Application Ref:	3/2026/0460			 Ribble Valley Borough Council www.ribblevalley.gov.uk
Date Inspected:	17/7/26 & 25/9/26	Site Notice:	17/7/26	
Officer:	BT			
DELEGATED ITEM FILE REPORT:				
				REFUSAL

Development Description:	Variation of condition 2 (approved plans and documents) on planning permission 3/2022/0082 (as varied under planning permission 3/2023/0816) to account for design development involving the redevelopment of the old garage site to provide new building that includes a cafe, community shop, retail unit, post office, community spaces together with a separate store/plant room.
Site Address/Location:	The Old Garage Site, Newton Road, Dunsop Bridge, BB7 3BB.

Client	THE DUCHY OF LANCASTER		
Contract	THE OLD GARAGE SITE DUNSOP BRIDGE		
Drawing title	PROPOSED ELEVATIONS		
Scale	Job No.	Drg No.	
1:100	HB106	1007

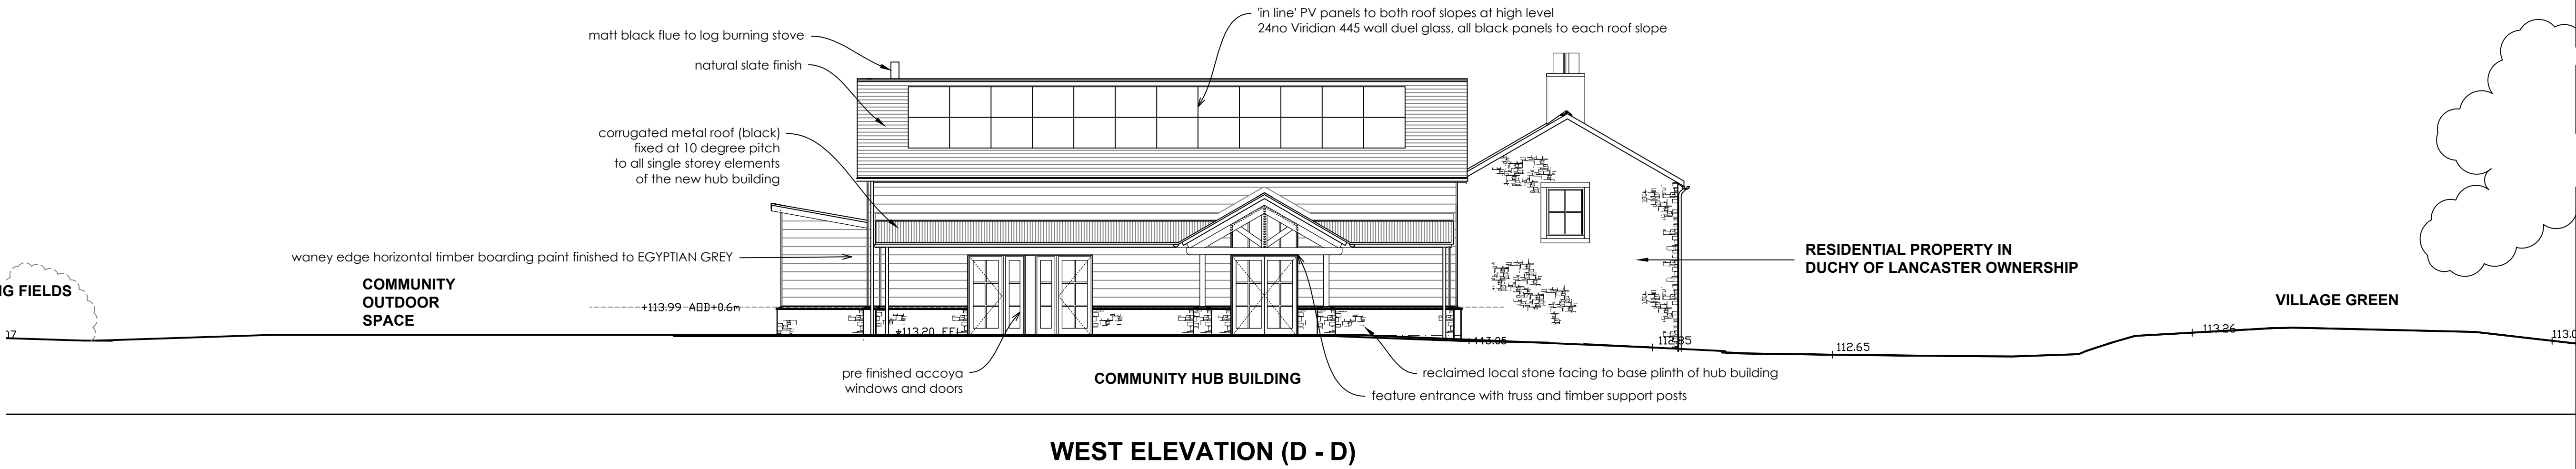
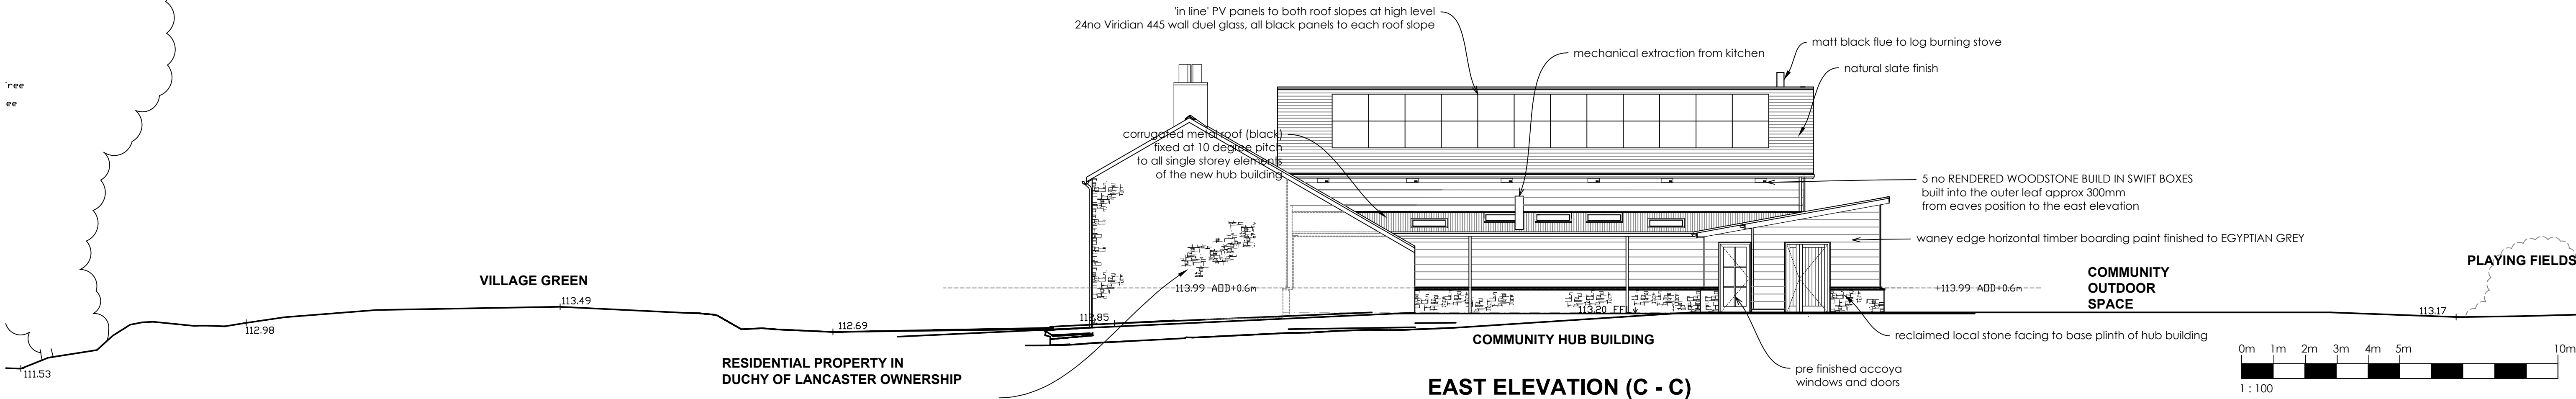
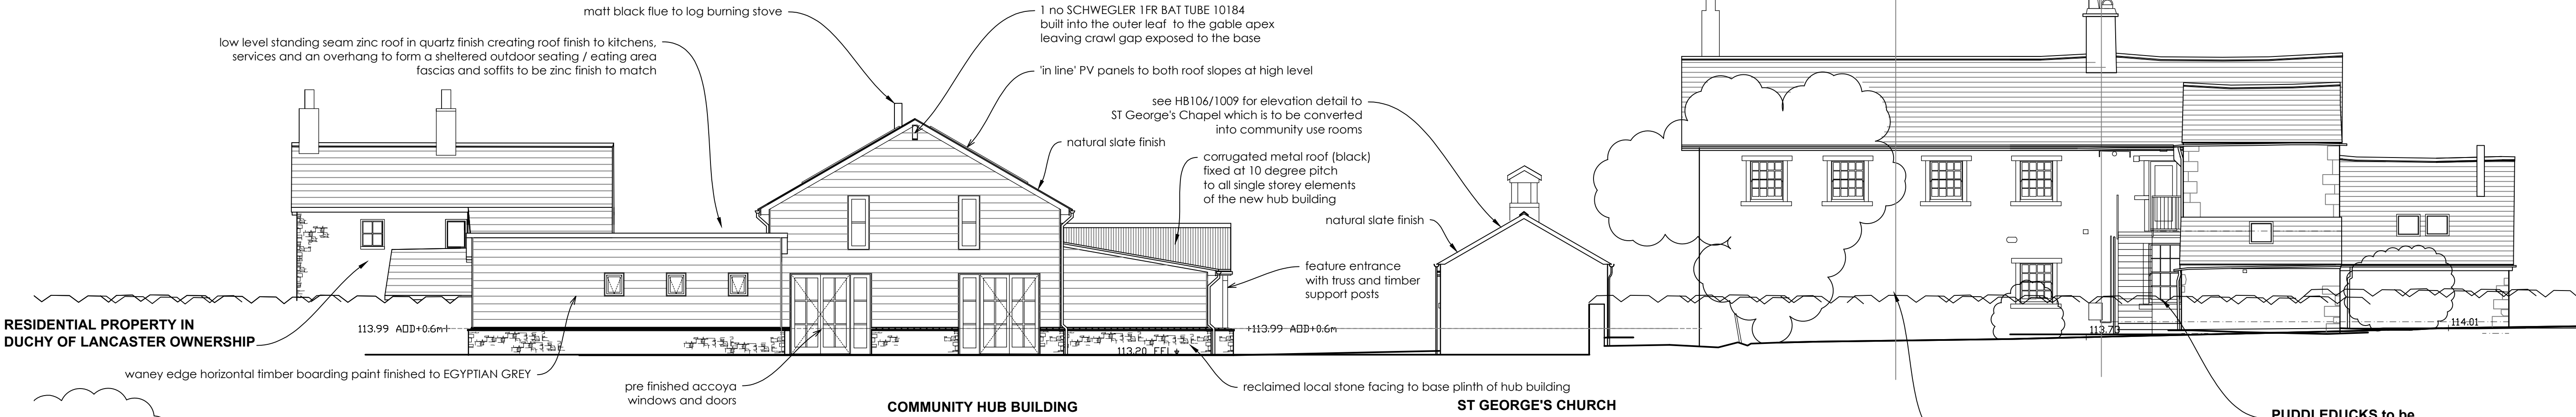
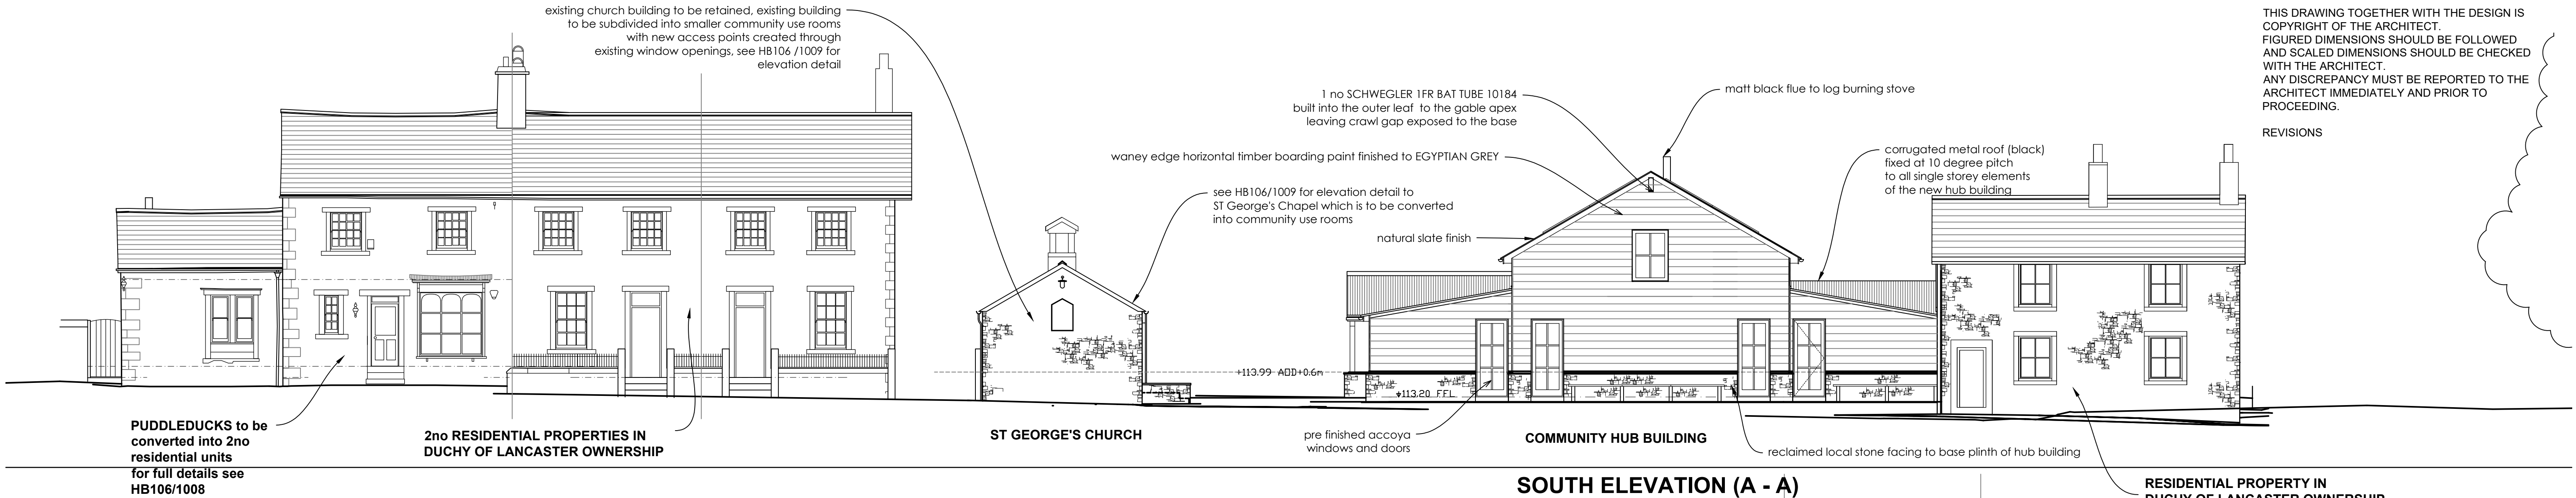
In this instance, the proposal seeks to introduce numerous changes to the design and external appearance of the development as previously approved. These changes include the omission of a previously approved link extension and introduction of a lean-to element to the Western elevation of the community hub building which would comprise a bulky and largely unsympathetic projecting gable feature and shallow sloping roof profile that would be at odds with the sloping symmetry of the community hub's Western roof profile, with the proposed lean-to element as a whole reading as a bulky and asymmetrical addition to the hub building. The proposal also seeks to introduce horizontal cladding to all external elevations of the community hub building (with the exception of stone plinth sections) which would be noticeably at odds with the natural stone vernacular of buildings within the immediate and wider locality. Further alterations proposed include the introduction solar panels to the main Eastern and Western roof slopes of the community hub building which would cover the large majority of the building's roof slopes with the solar panels also being highly visible in the public realm with the remainder of the development. In this instance the application site occupies a rural setting with roof mounted microregeneration equipment being predominantly absent on properties in the immediate area therefore it is considered that the proposed solar panels would read as overtly modern and incongruous features that would be predominantly at odds with the rural character of the area. Moreover, the proposed development as a whole would be largely visible in the public realm from within and around the application site and would therefore carry a discernible visual impact.

Accordingly, the proposed development by virtue of the bulk, massing and asymmetry of the proposed western lean-to extension and proposed introduction of cladding and microregeneration equipment would constitute an incongruous and unsympathetic form of development which would detract from the rural character and visual amenities of the area. As such, the proposed development would have a harmful impact that would neither enhance or conserve the visual amenities of the surrounding National Landscape and would therefore fail to satisfy the requirements of Policies DP3 (1) and N4 (1) of the NPPF (2026) and Key Statement EN2 and Policies DMG1 and DME5 of the Core Strategy.

- 01:** The changes sought to the originally approved development would amount to a development that would be substantially different from the development approved under planning application 3/2023/0816 in terms of design and external appearance and as such would not fall within the realm of a minor material amendment. Furthermore, the proposed development by virtue of the bulk, massing and asymmetry of the proposed Western lean-to extension and proposed introduction of cladding and microregeneration equipment would constitute an incongruous and unsympathetic form of development which would detract from the rural character and visual amenities of the area. As such, the proposed development would have a harmful impact that would neither enhance or conserve the visual amenities of the surrounding National Landscape and would therefore fail to satisfy the requirements of Policies DP3 (1) and N4 (1) of the NPPF (2026) and Key Statement EN2 and Policies DMG1 and DME5 of the Core Strategy.
